**Your Ref:** OWPC21891  
**Our Ref:** FP/32/19/PL 13-02-2019  
**Please ask for:**  
Richard Castro-Parker

Conversion of part retail unit & storage area to form 9 No. residential units consisting of  
3 No. 1 bed & 6 No. 2 bed dwellings & new access to rear.

107 Felpham Way Felpham

Thank you for your internet representation made on 29th March 2019 which has been recorded as '**an objection**' with the comments as follows:

SITE PLAN (Proposed) @ 1:200

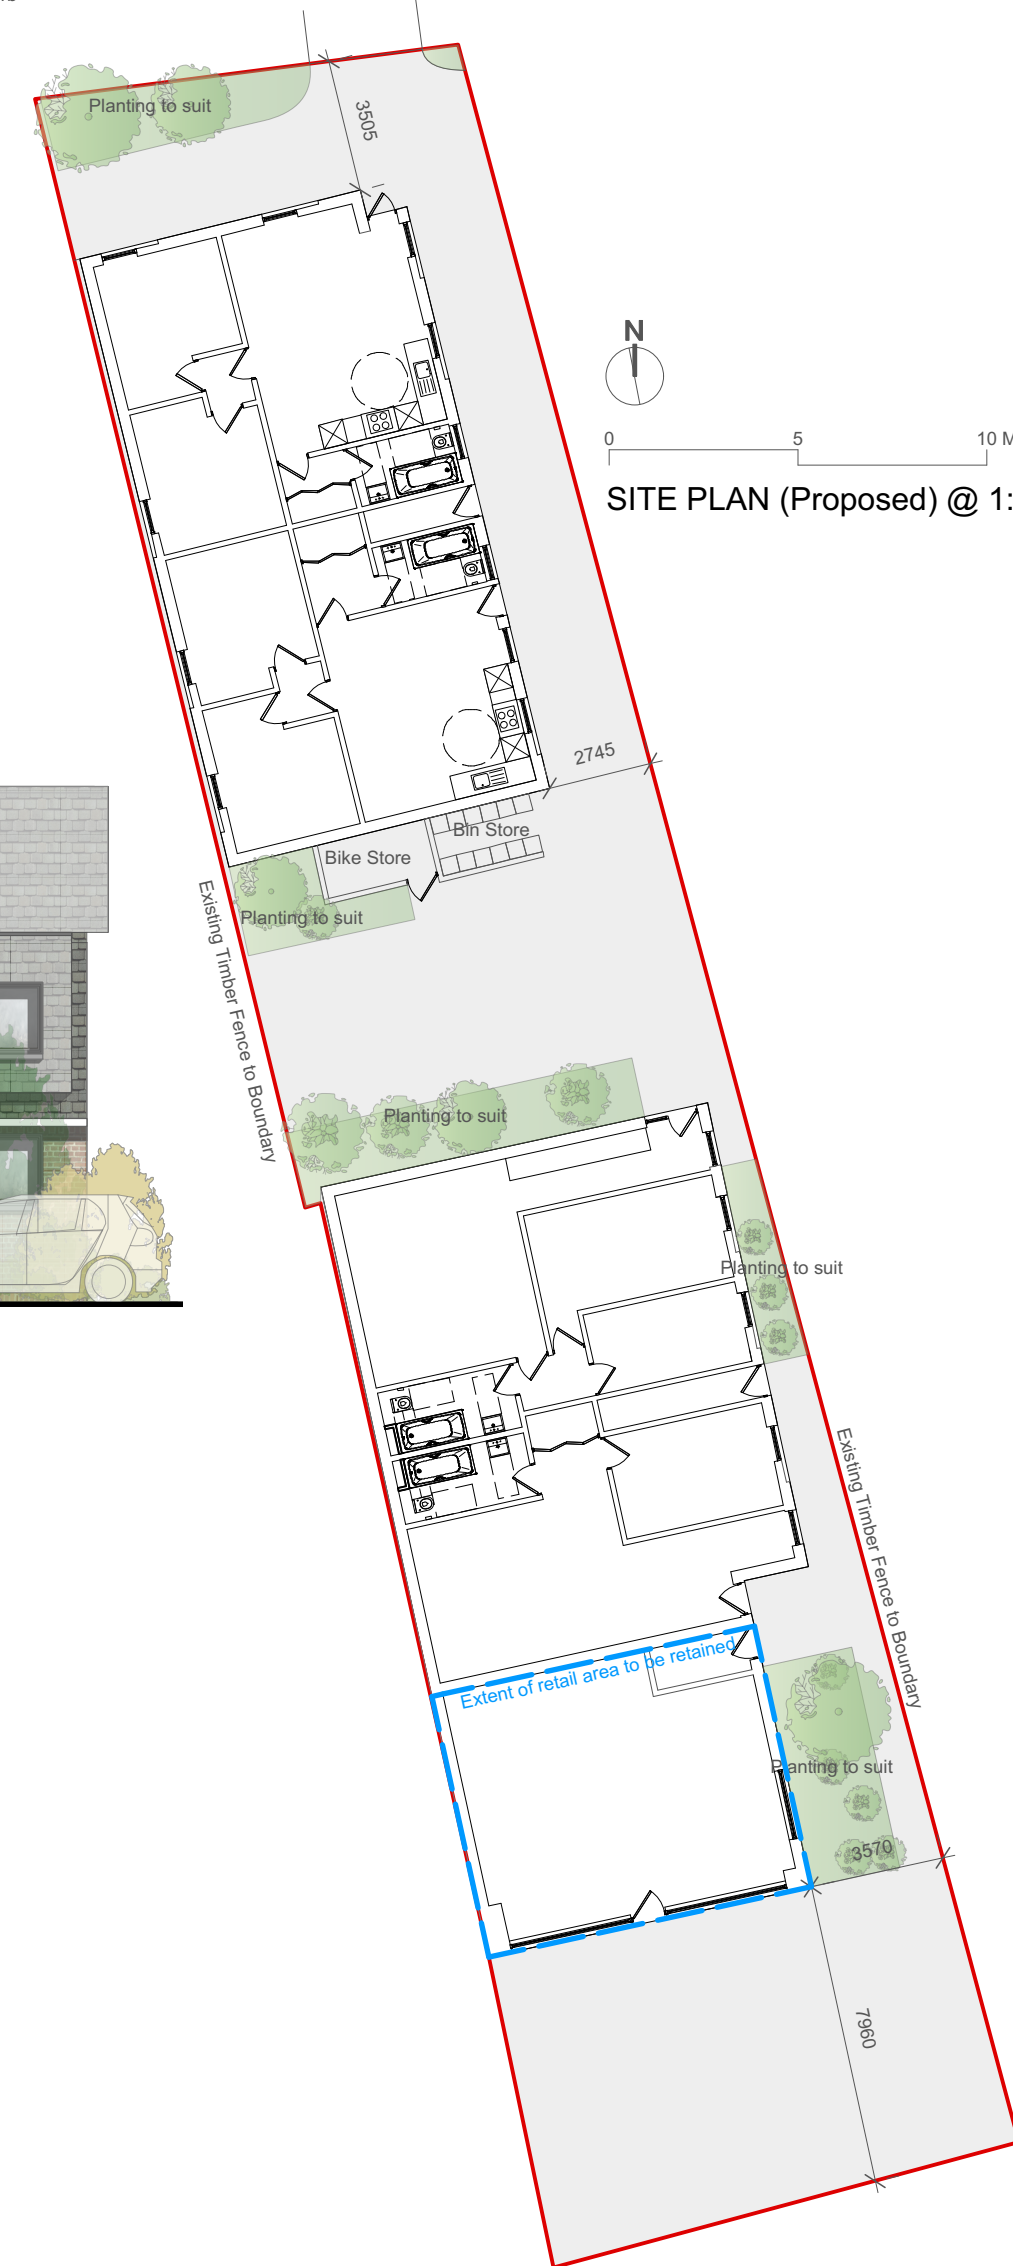
- 1 The northern block touches the boundary of 1 Rainbow Cottages, this would mean all privacy in the garden and rear rooms of 1 Rainbow Cottages would be lost; unless all overlooking windows were of obscured glass. Alternatively the block should be move further east, unfortunately this would then cause similar problems to 2 Sunnyside Cottages.*

- 2 Parking spaces for 9 flats. We would anticipate approximately nine vehicles have not been provided for within the boundaries of the development. Given 6 of the proposed flats are for 2 bedroom flats one should work on the principle that a possible 15 cars could need to be regular accomodated, without the need for visitor parking.*

- 3 Access to the blocks is via Flax Mean. This is a cul-de-sac with very limited parking space for the private properties and council bungalows accessed at present. Access is also required for emergency vehicles given that all of the Flax Mean properties are for those over state pension age.*
